CITY OF ALBUQUERQUE
 PLANNING DEPARTMENT
 DEVELOPMENT REVIEW BOARD

Project# 1003612

THOMPSON ENGINEERING CONSULTANTS, INC agent(s) for DRAGONFLY DEVELOPMENT request(s) the referenced/ above action(s) for all or a portion of 94TH STREET NW AND J09 37, TOWN OF ATRISCO GRANT, SECTION 16, TOWNSHIP 10N, RANGE 2E, zoned SU-2/R-LT, located on the south side of ENDEE RD NW between 98TH ST NW and 94TH ST NW containing approximately 7.0386 acre(s). (J-9)

LEGEND

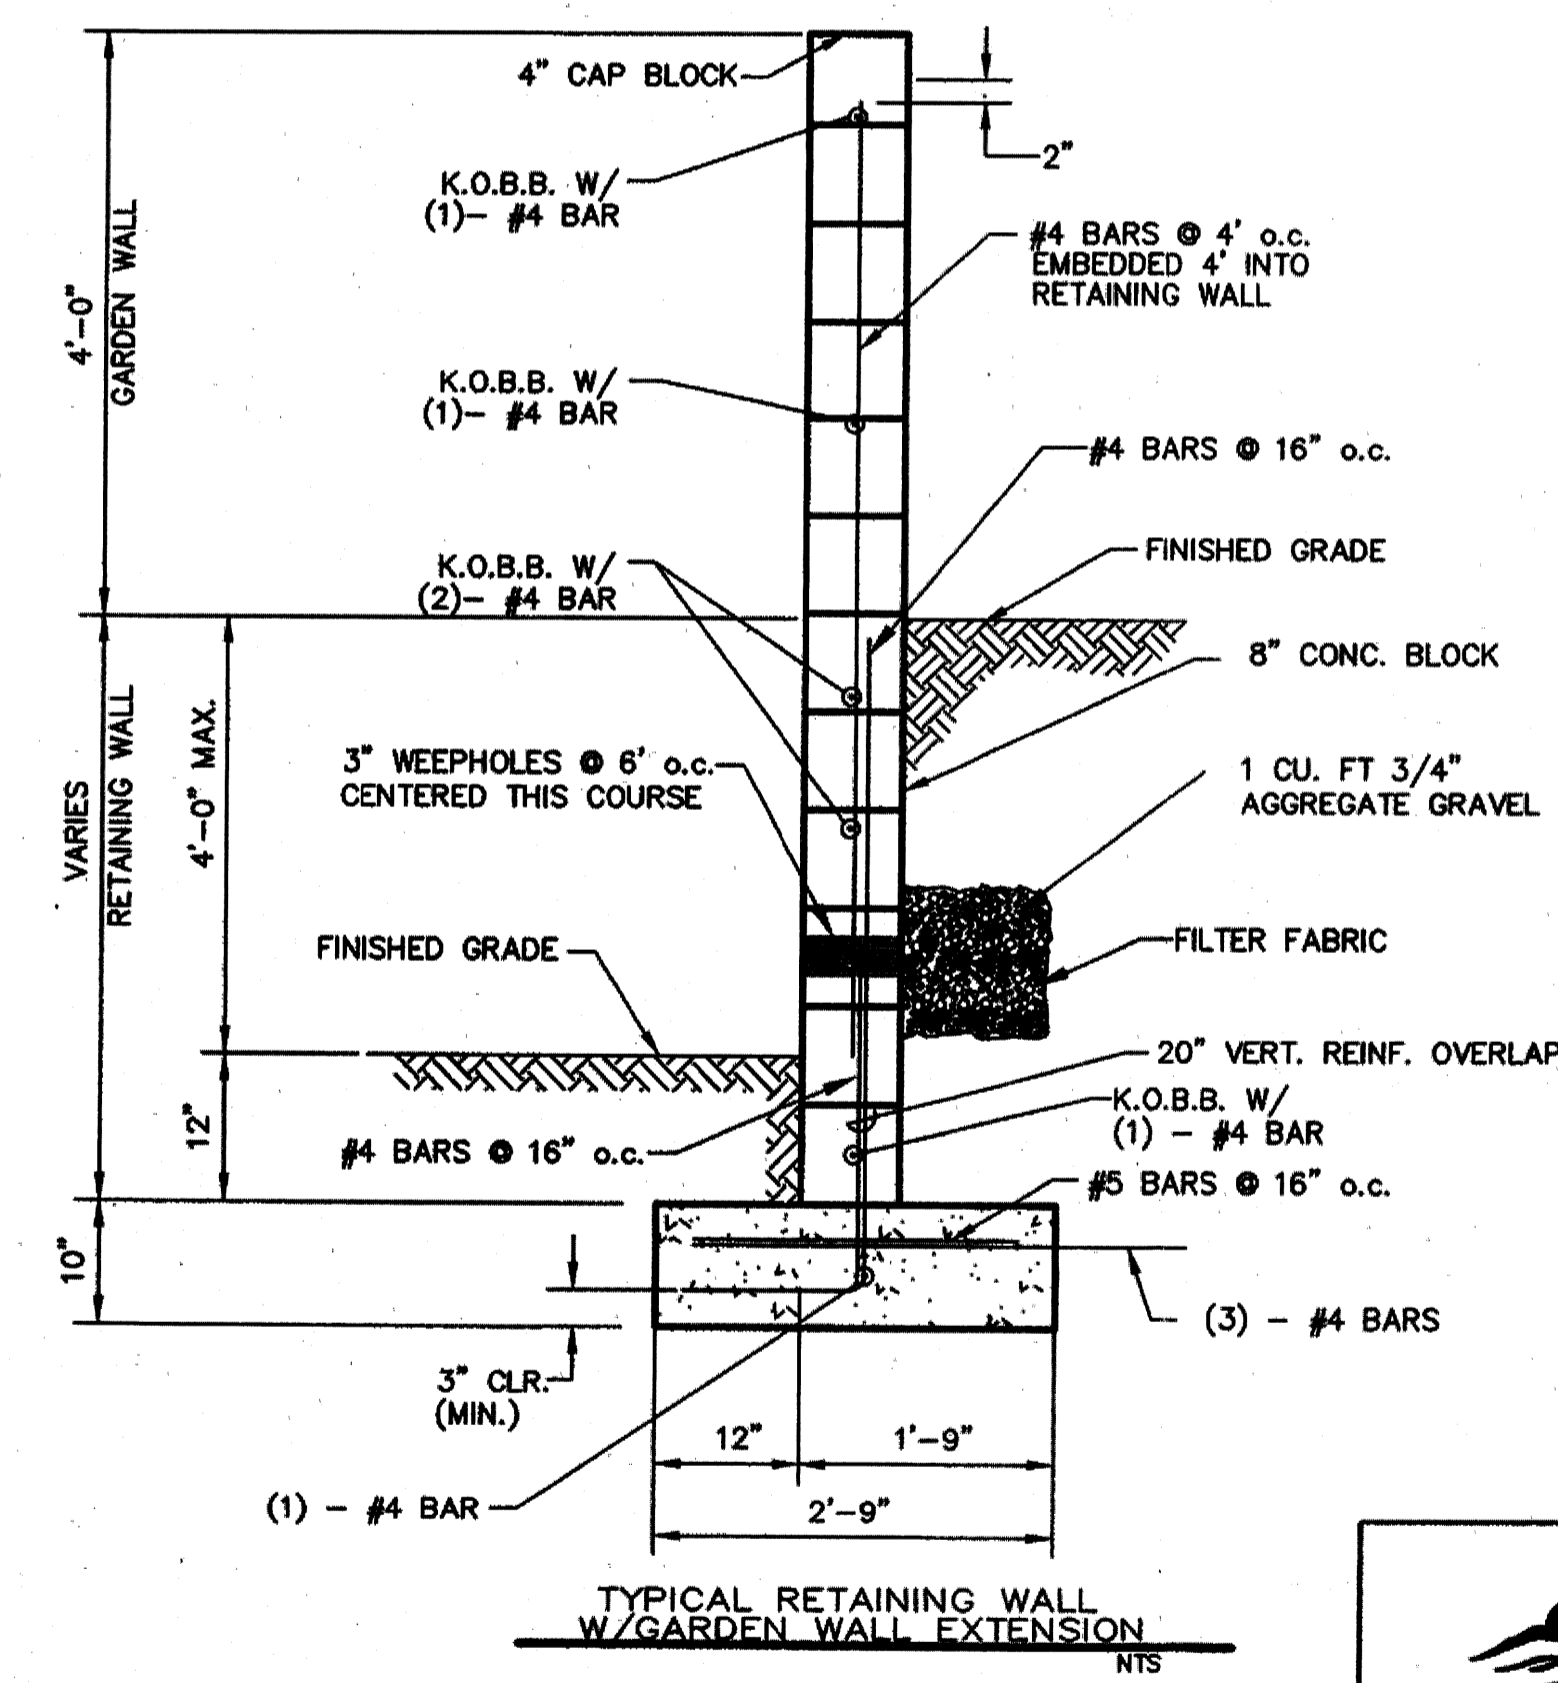
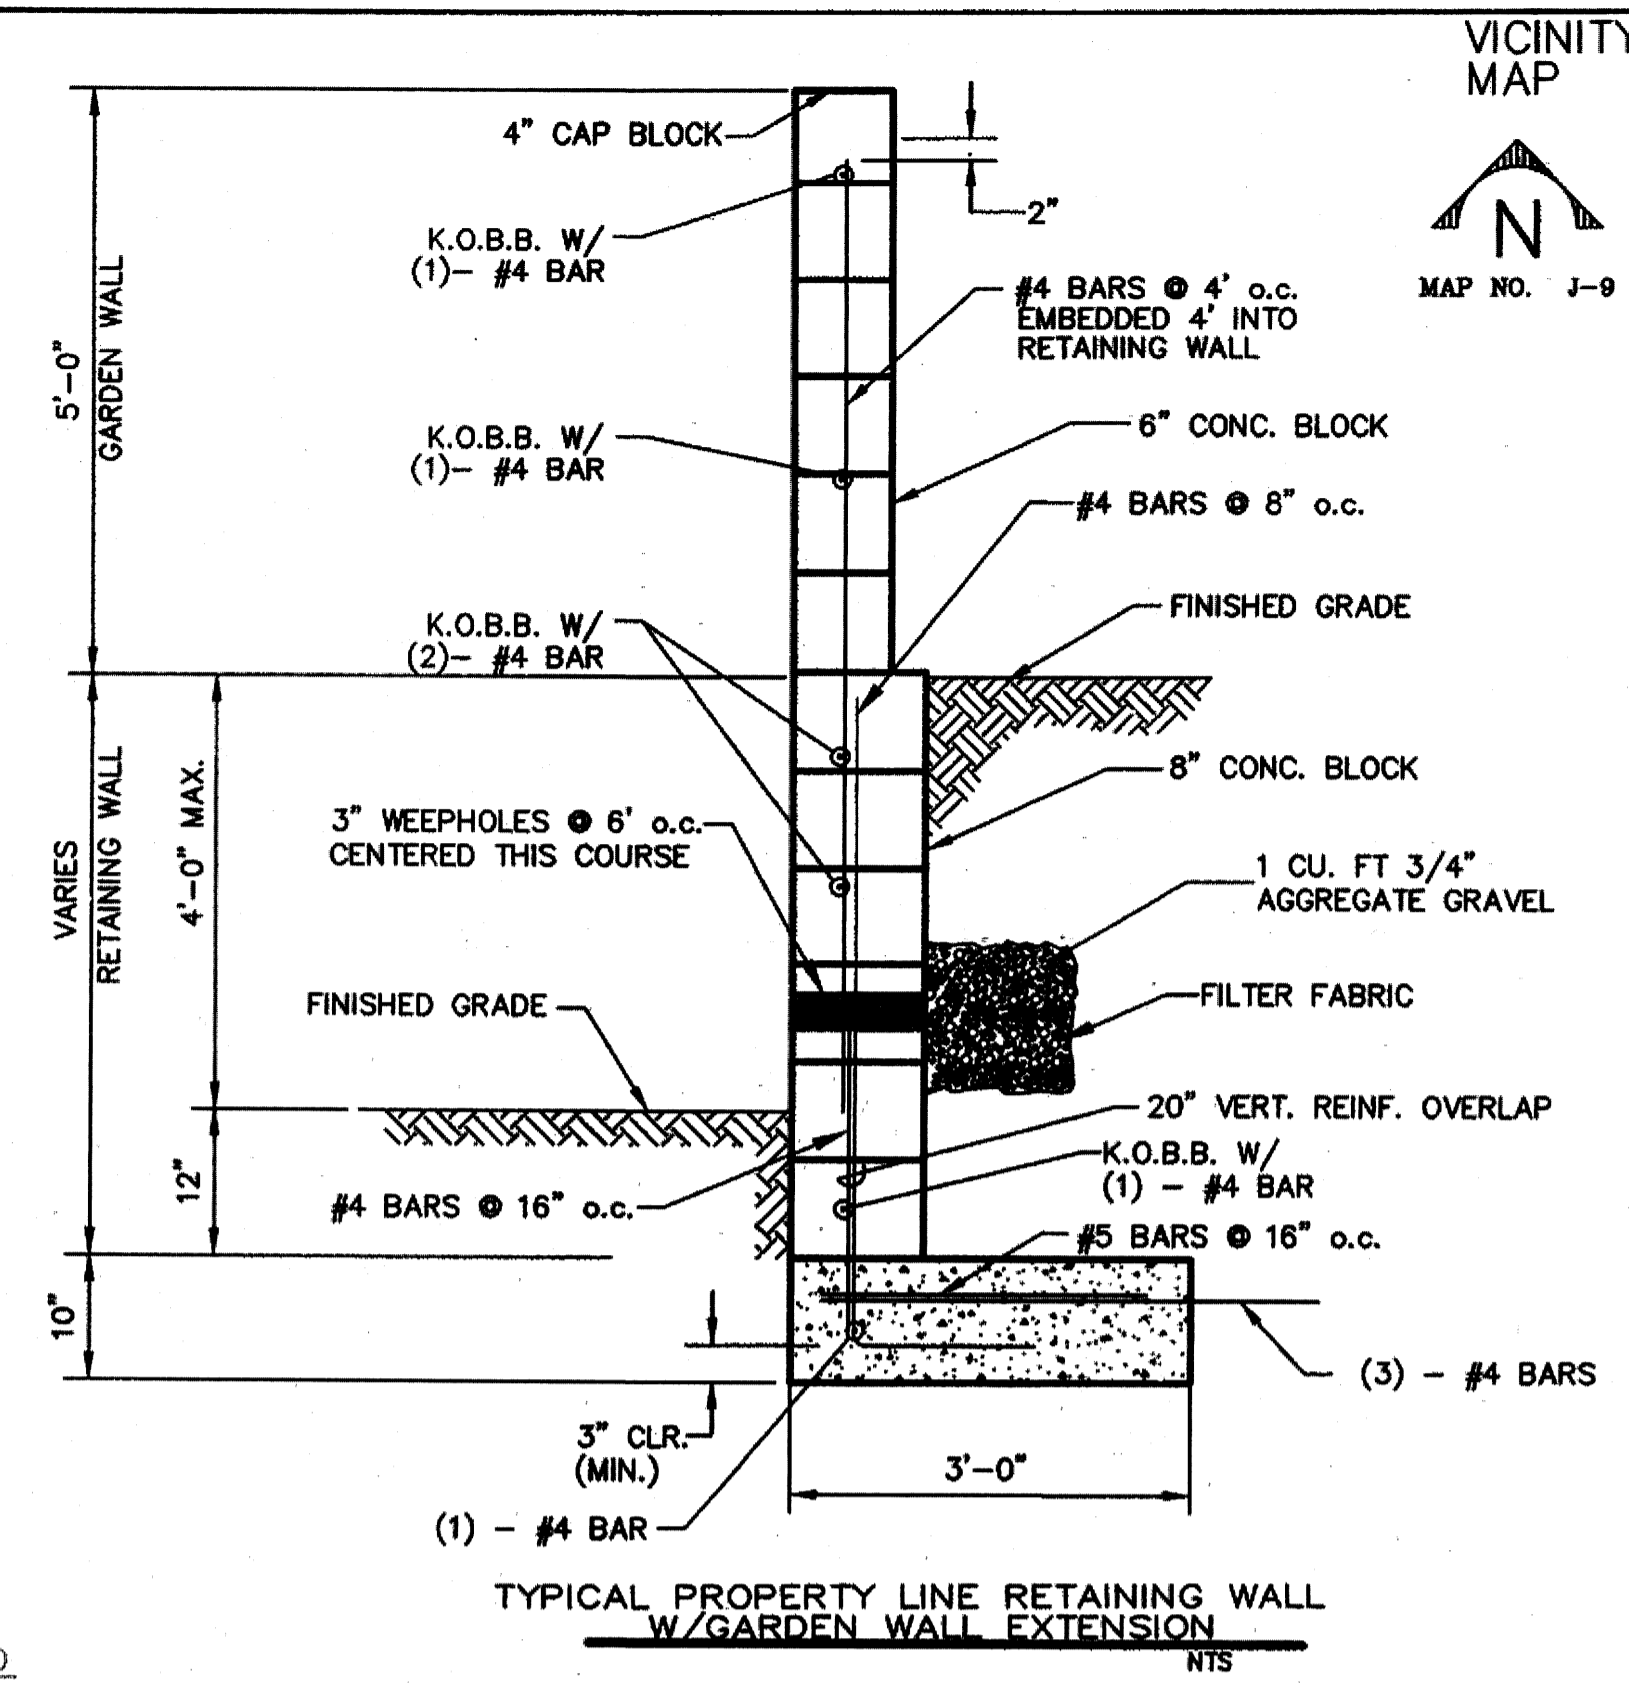
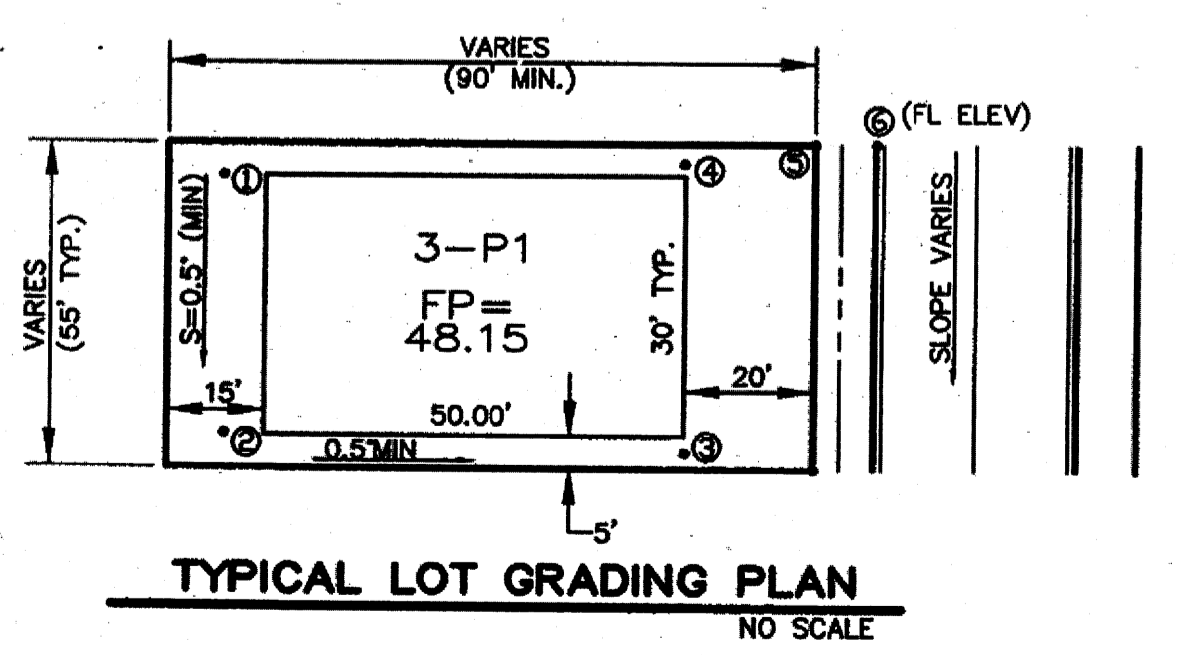
The Zoning Code restricts residential wall height to a total of 8 feet – the section for “PROPERTY LINE RETAINING WALL” on the proposed grading plan does not comply. Please clarify the existing elevations on adjoining properties, particularly the western boundary.
